Final Acceptance (FA) Punchlist
EPC - DPW - Stormwater Section

Project Name:	Creekside at Lorson F1
EDARP Filing Number(s):	CON1910
ESQCP Number:	ESQ 1911
Attendees:	DPW SW: Natasha Grimaldo, Ben Jones DPW Planning: N/A Developer: Jeff Mark/Lorson LLC
Date of Walk-Thru:	2/14/2023
Walk-Thru Number:	1 st

POND C1-R
FULL SPECTRUM
OUTLET STRUCTURE DETAILS

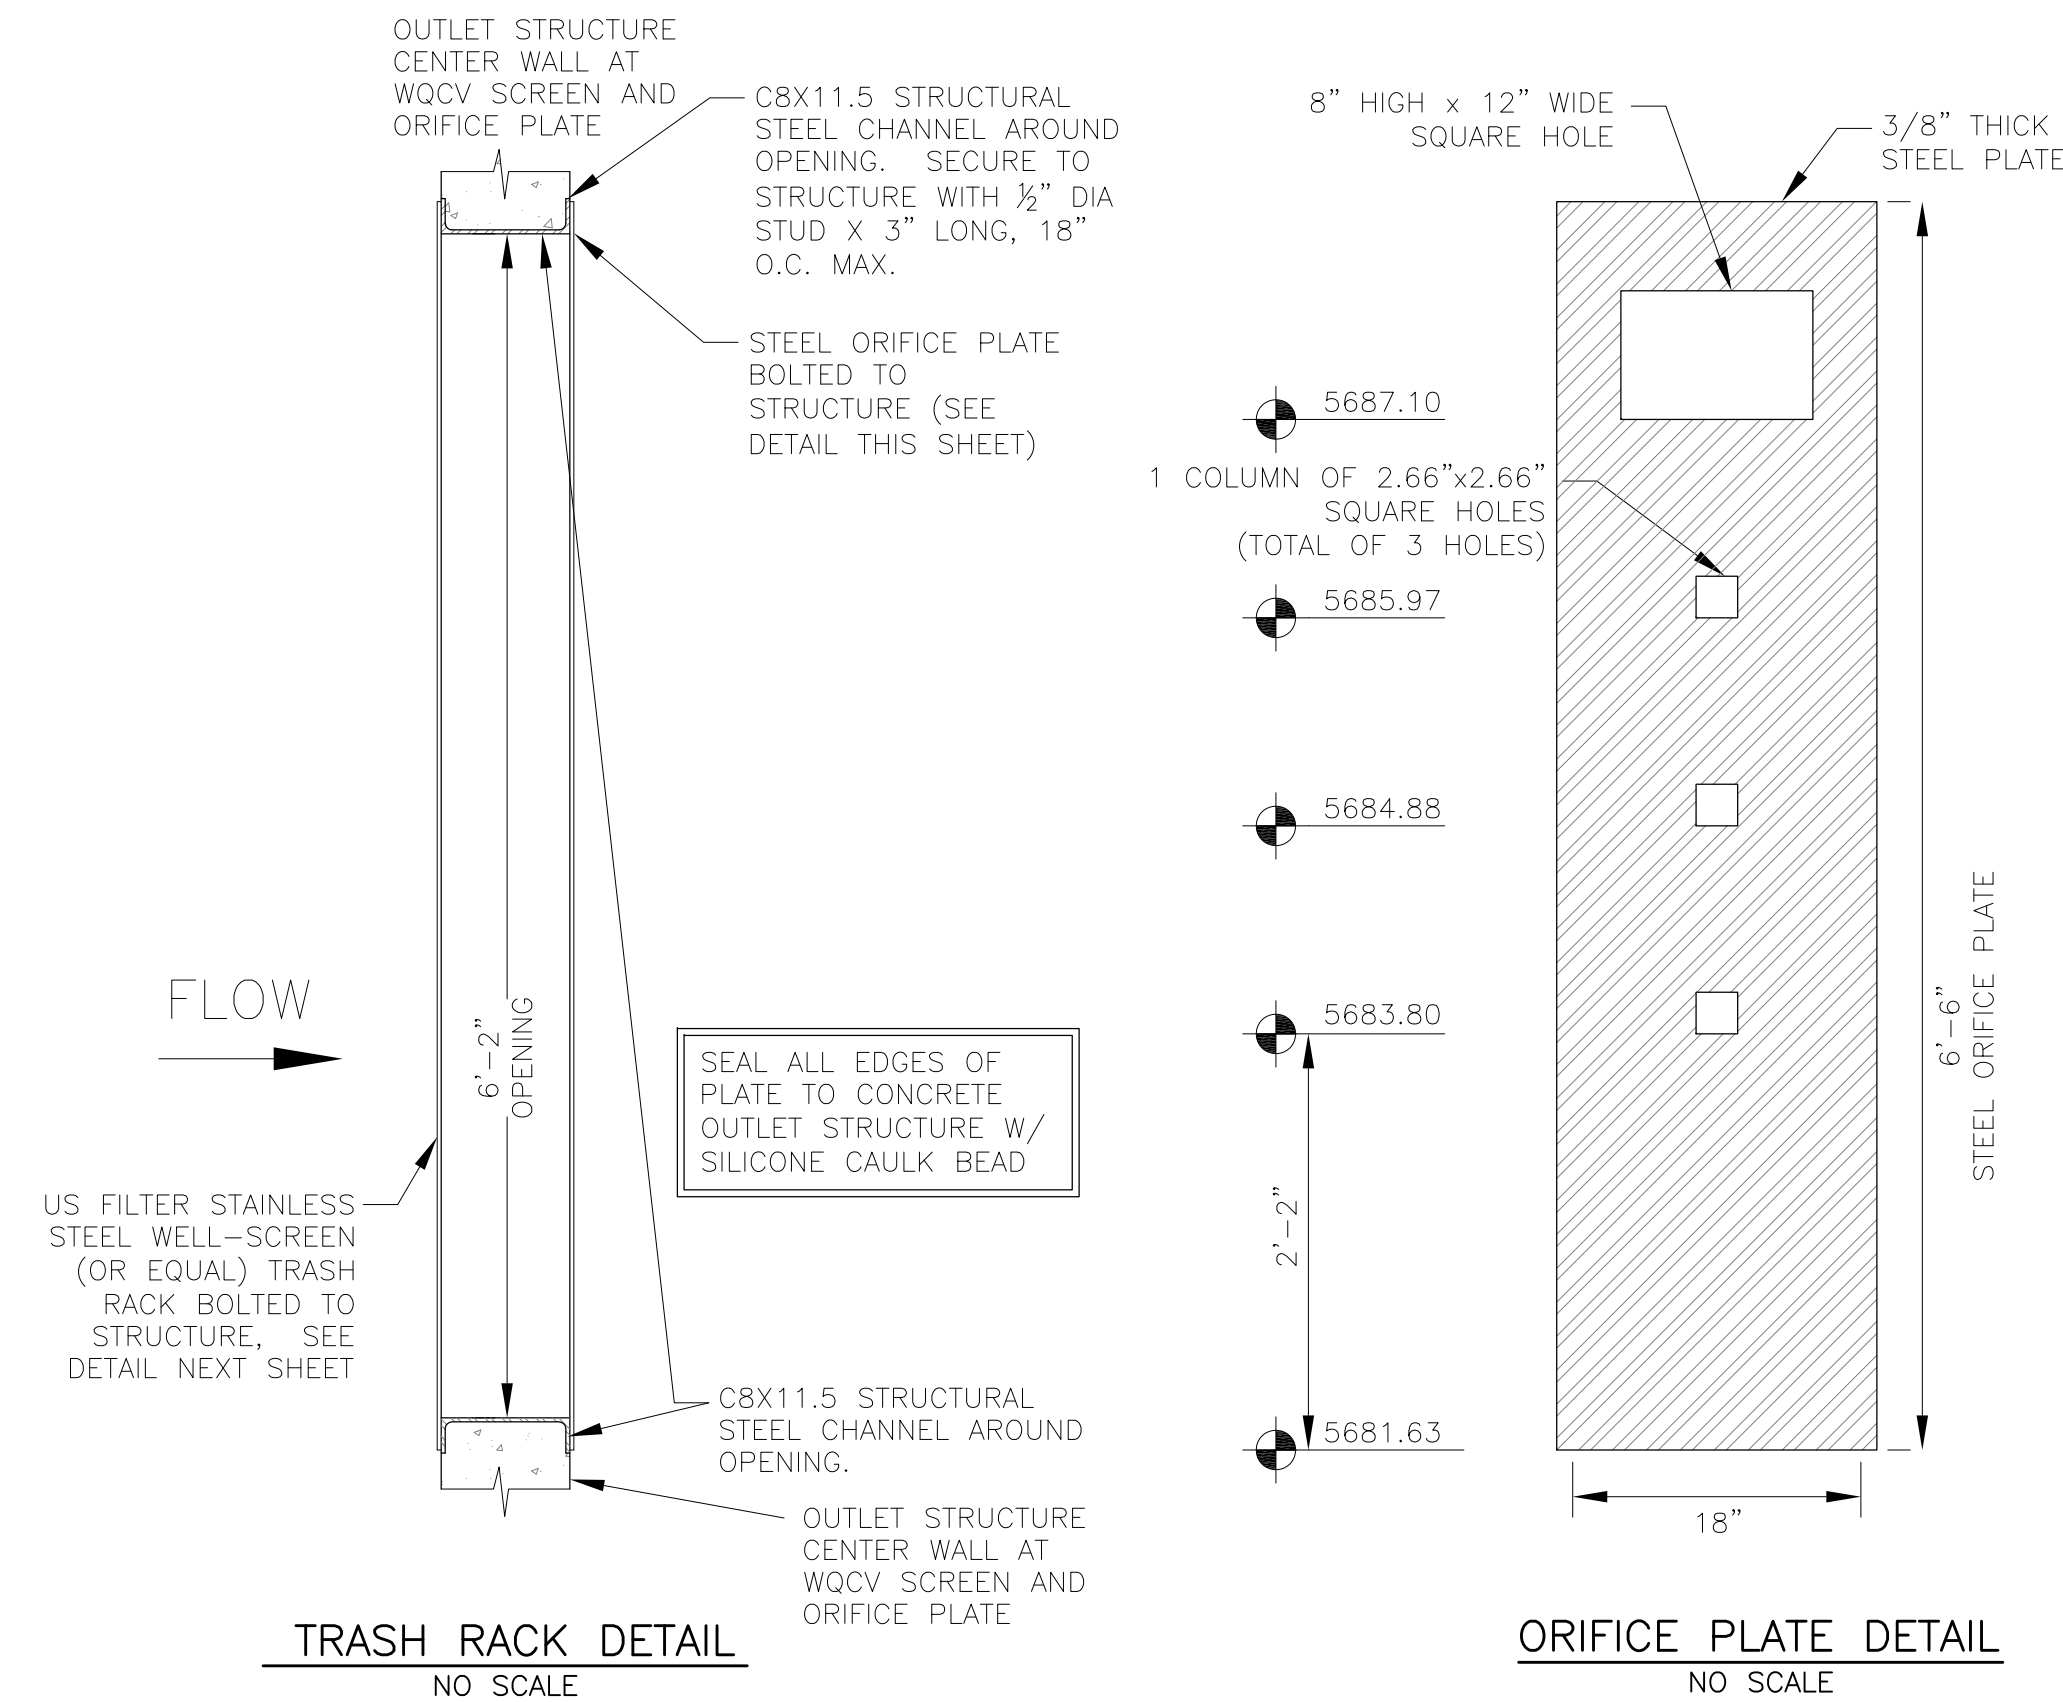
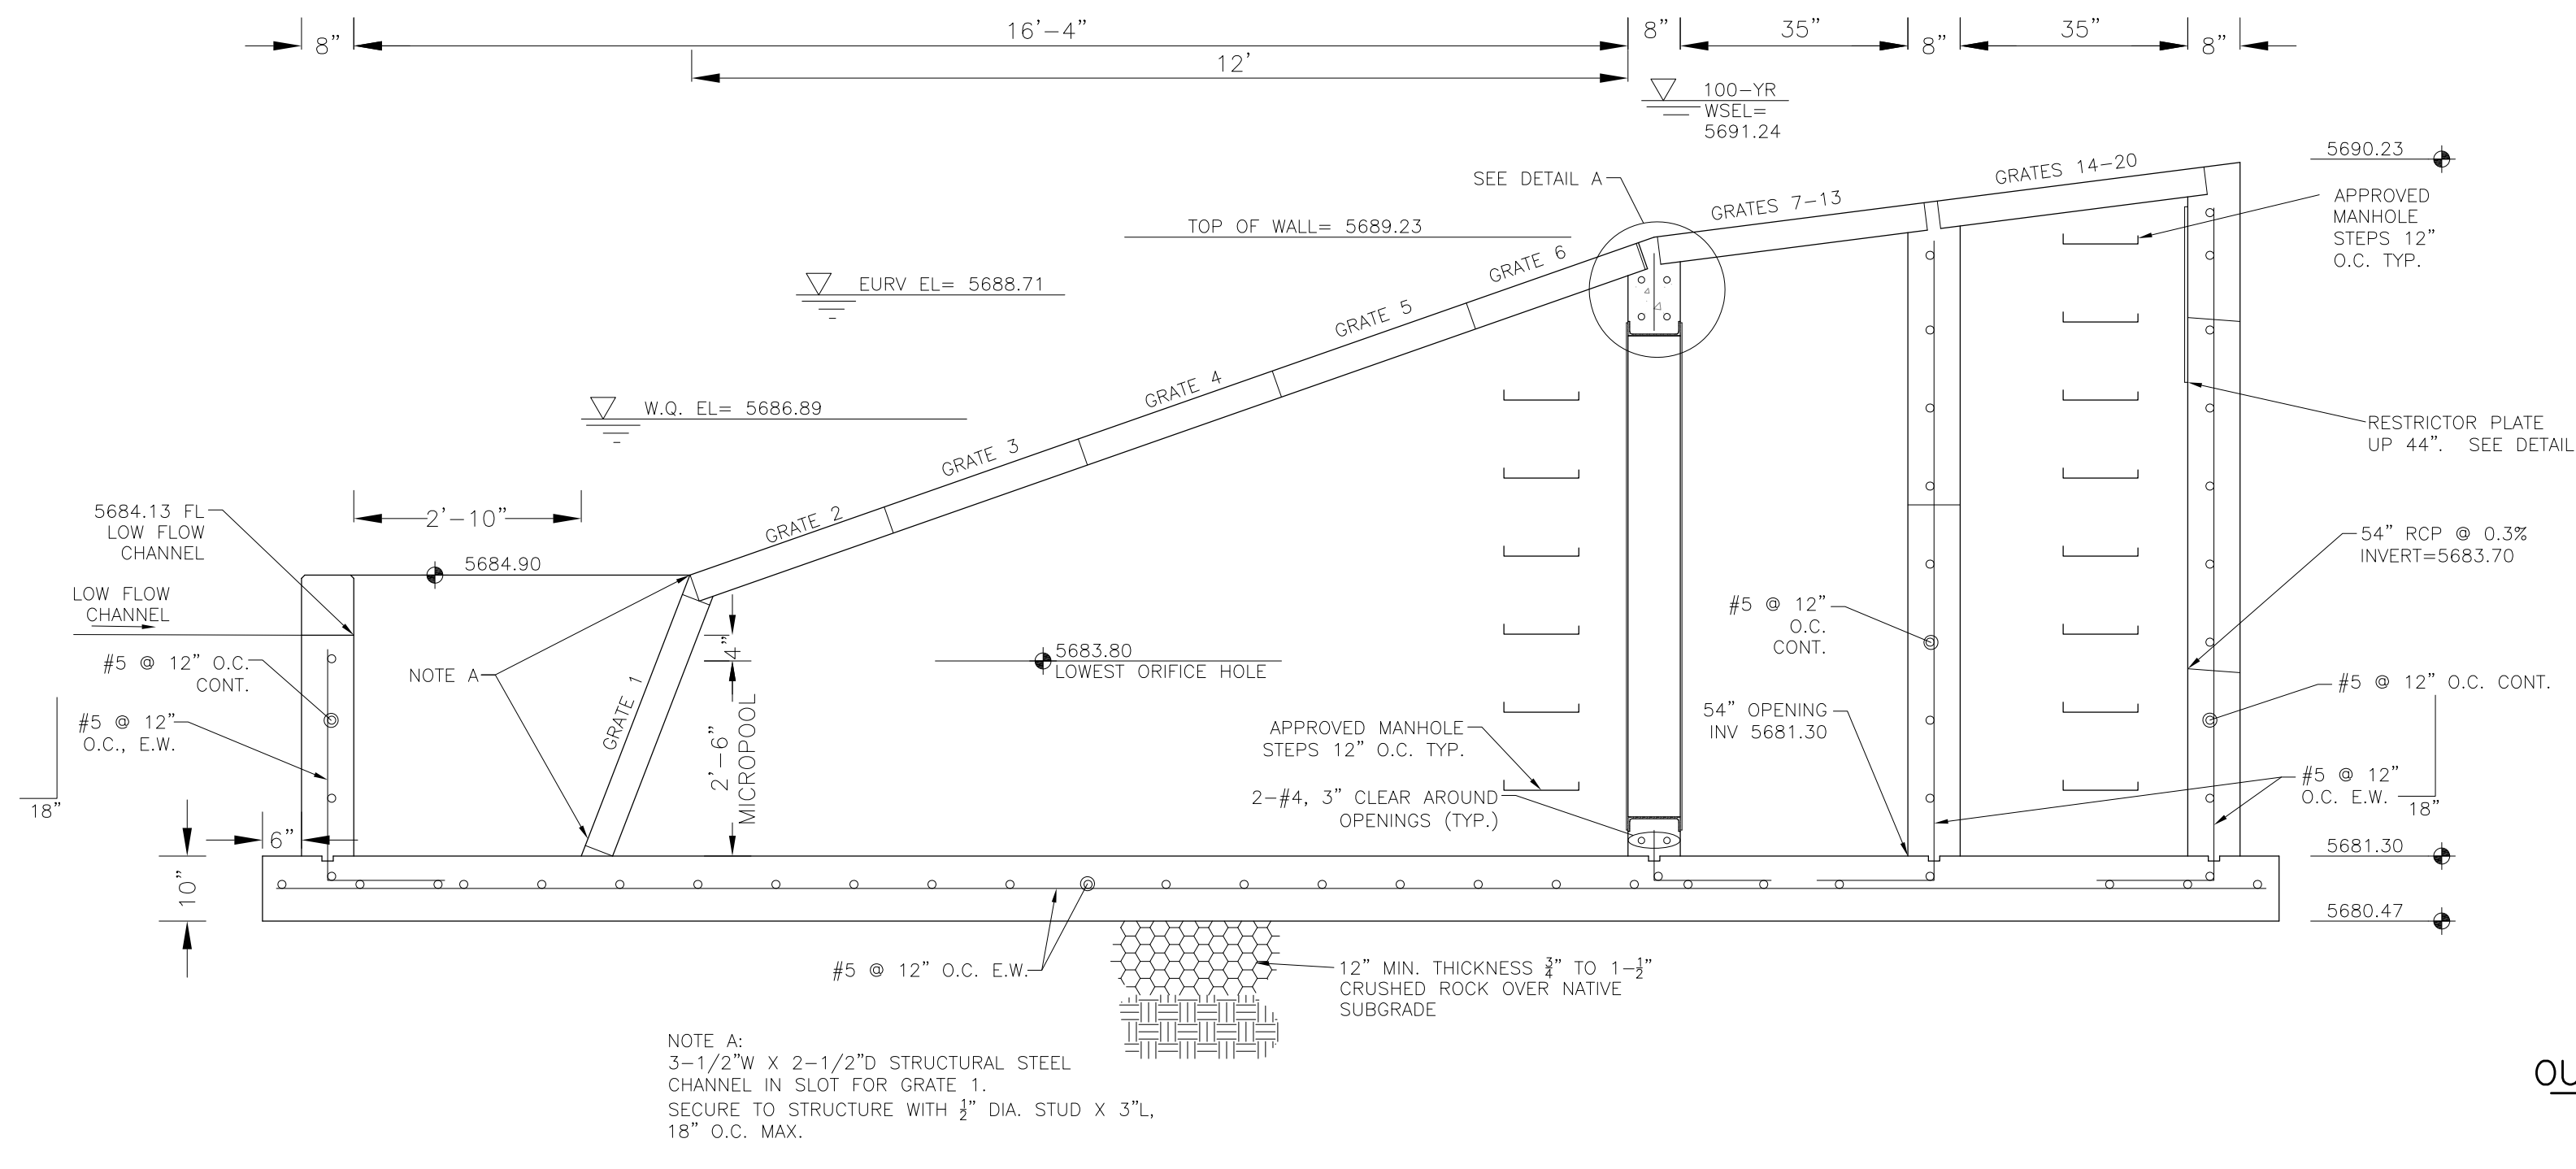
Photo 1: Pond C1-R: Implement missing bolts on outlet structure top grates (approximately 11 missing).
